Tel: 01895 250230  
Case Officer: Ed Laughton  
Email: [elaughton@hillingdon.gov.uk](mailto:elaughton@hillingdon.gov.uk)  
Date: 6th January 2022  
Our Ref: 924/PRC/2021/187

**RE: Extensions to care home facility**  
**SITE: Denville Hall Ducks Hill Road Northwood**

ELEVATION 3

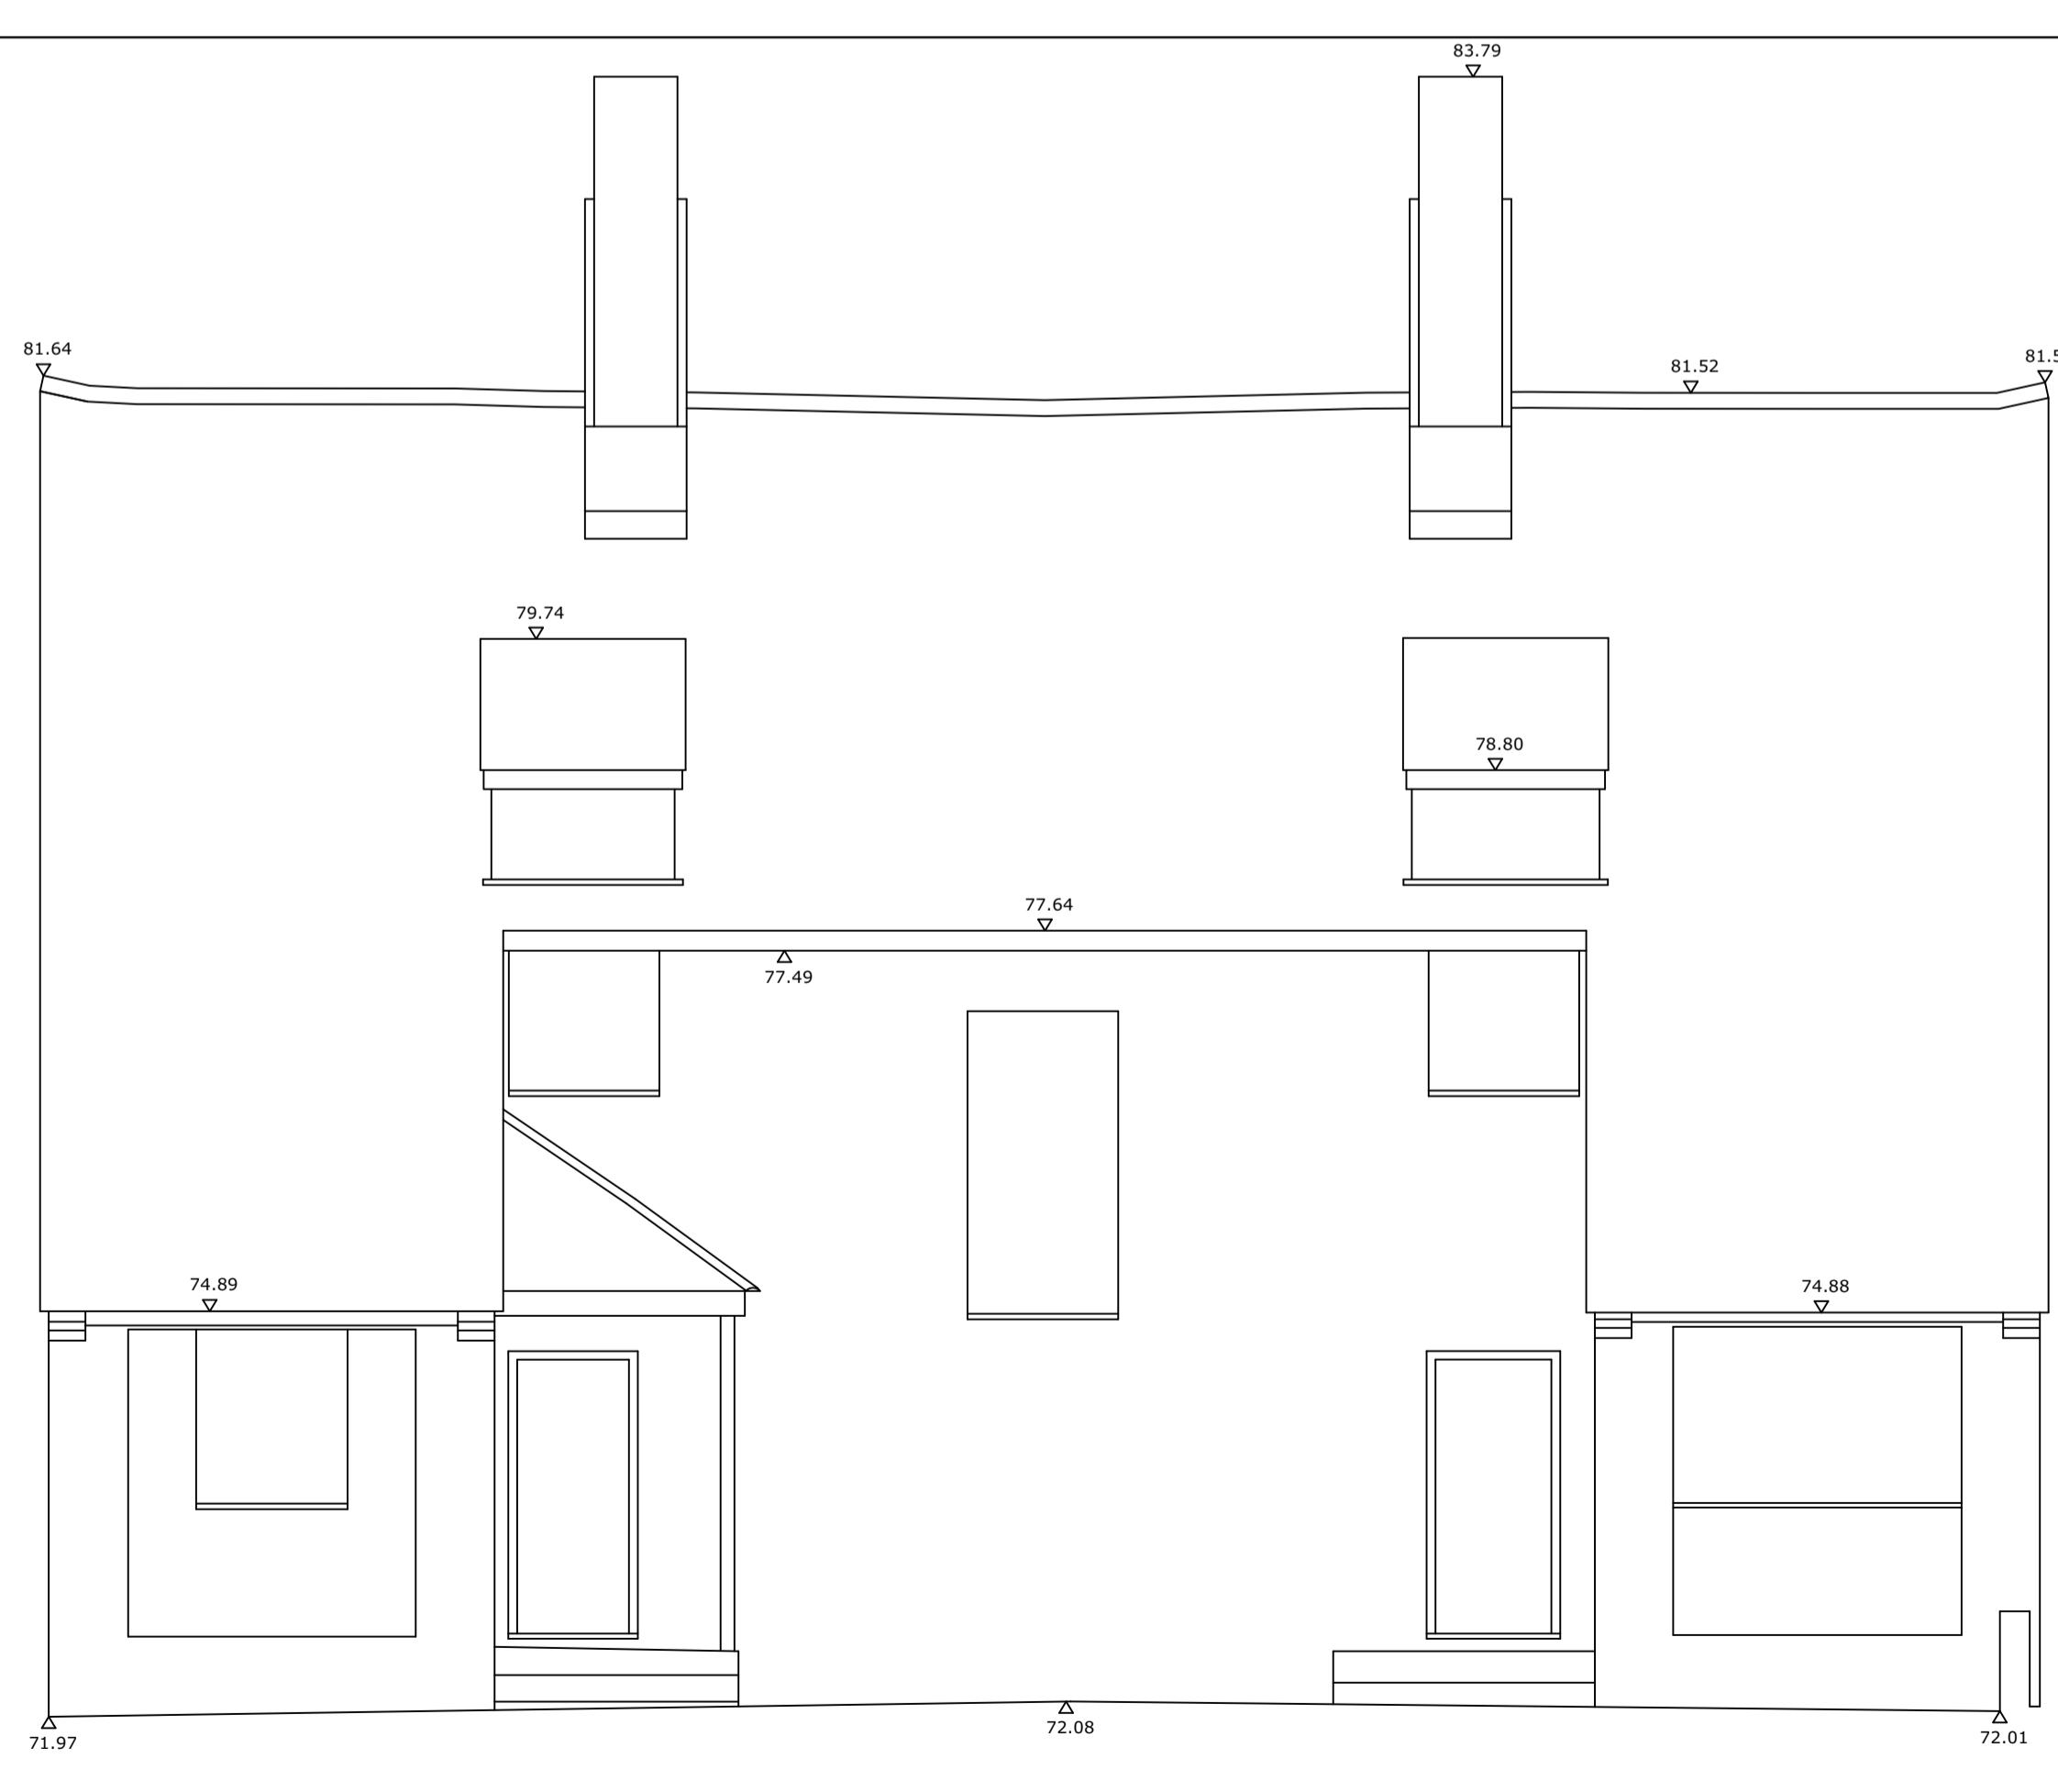
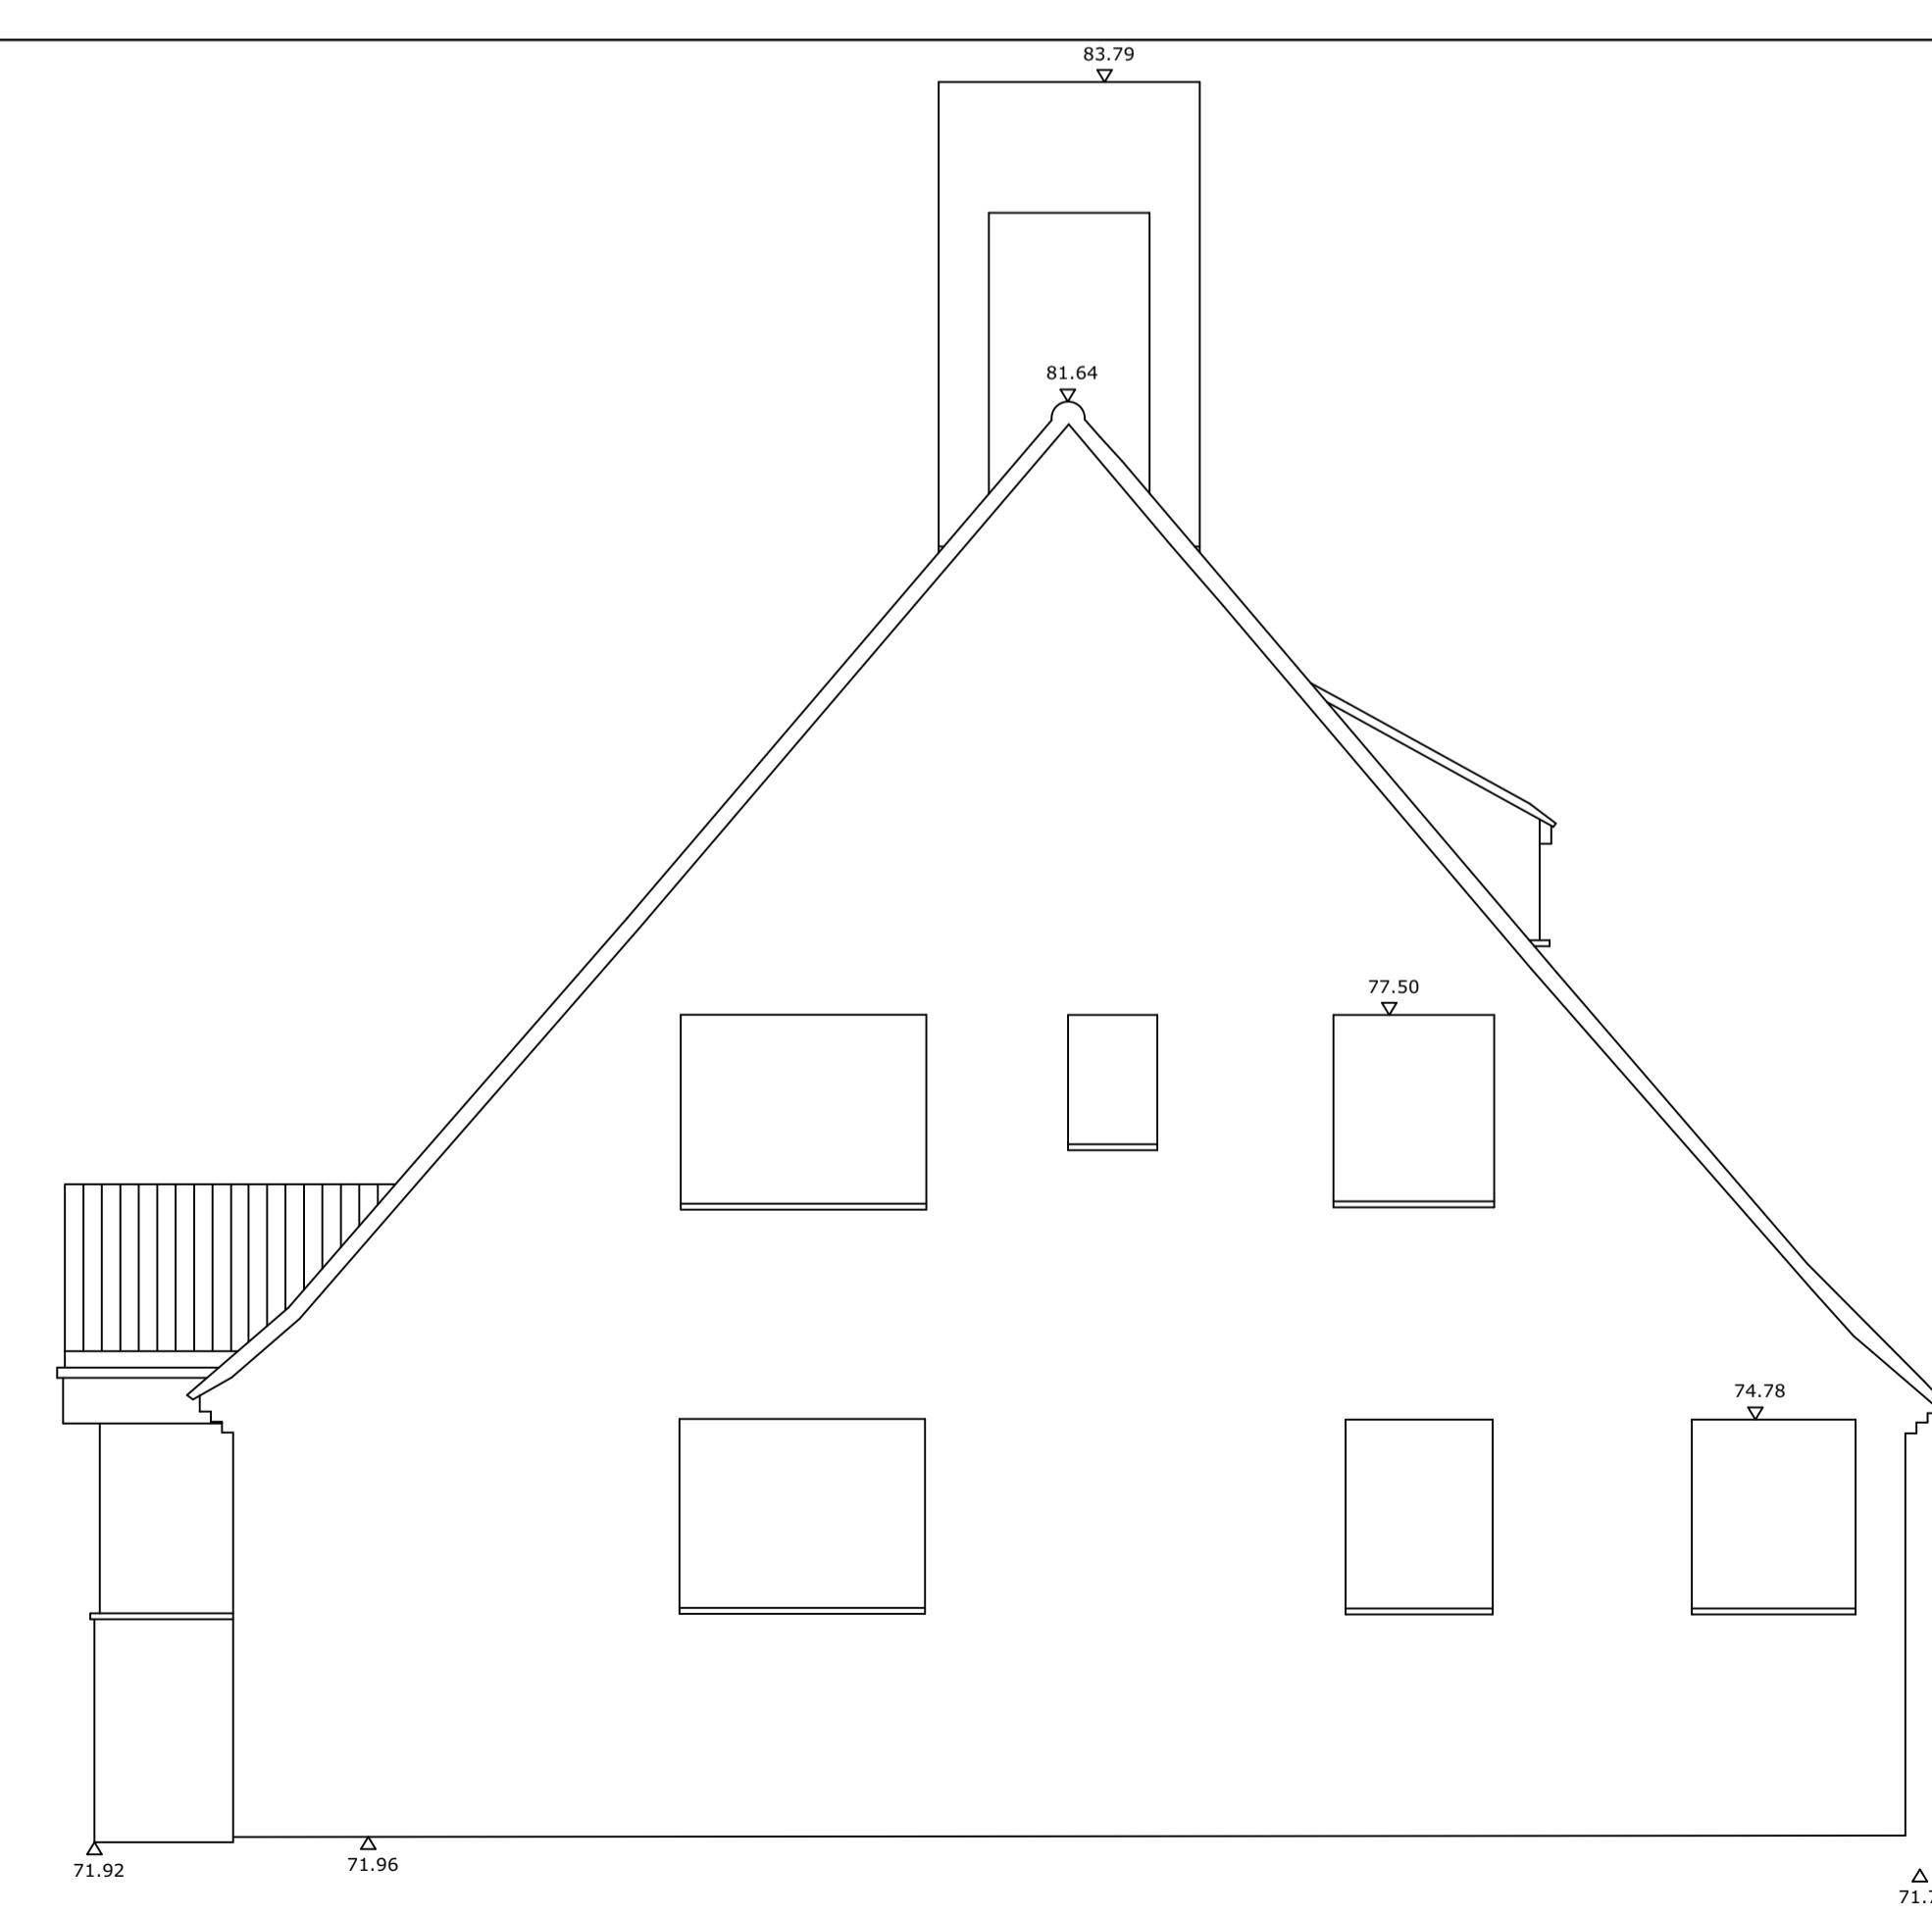
The proposed Building A would result in a larger and bulkier built form, directly adjacent to the existing Listed Building. The building would have a greater presence, particularly due to the increased height and no longer sit quietly within the setting of the Listed Building, exacerbating the harm already caused.

As proposed, Building A would be considered unacceptable and fails to preserve the setting of the Listed Building.
